Application Ref:	3/2025/0793			 Ribble Valley Borough Council www.ribblevalley.gov.uk
Date Inspected:	23/10/2025	Site Notice:	N/A	
Officer:	EP			
DELEGATED ITEM FILE REPORT:				
				APPROVAL

Development Description:	Proposed demolition of existing rear conservatory and construction of single-storey rear extension and new front porch. Addition of new render and composite boarding to external elevations and proposed new roof to existing garage.
Site Address/Location:	11 Whittam Crescent, Whalley, BB7 9SD.

PROPOSED SITE PLAN AT 1:200

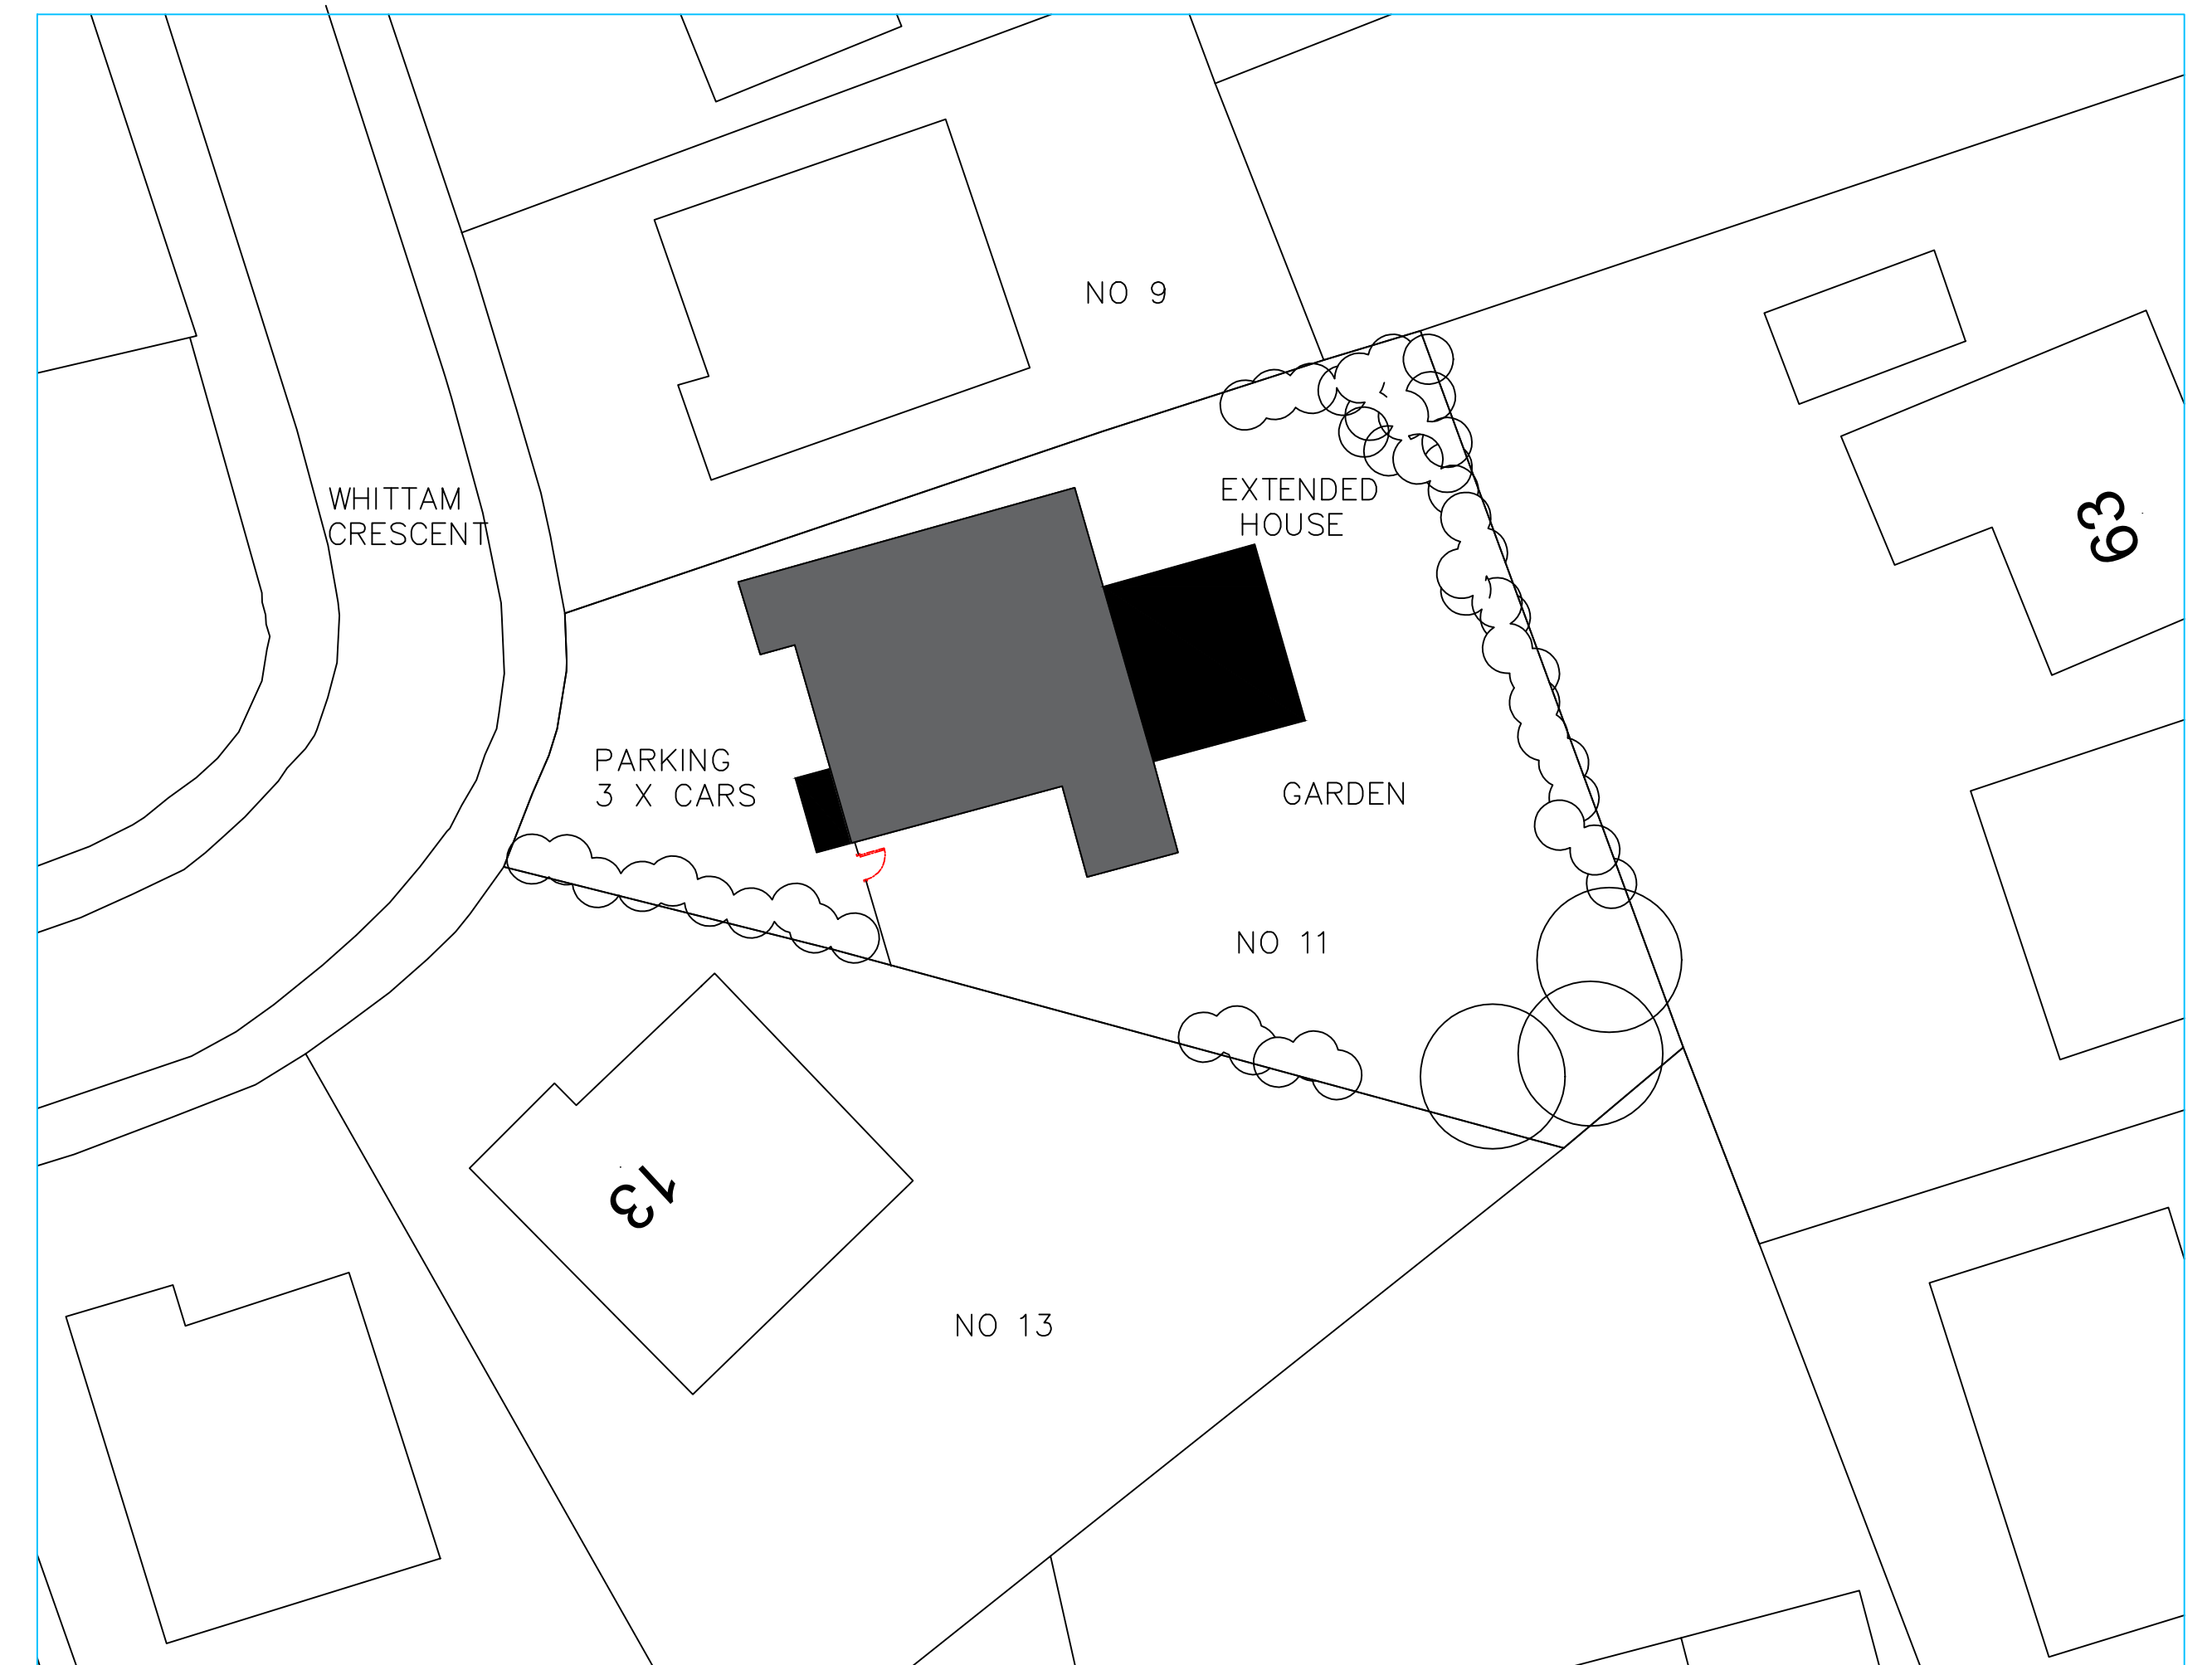
Lancashire County Council Highways have been consulted on the proposed development and raised no objection. Three parking spaces could be accommodated on the driveway to the front of the property which accords with parking standards.
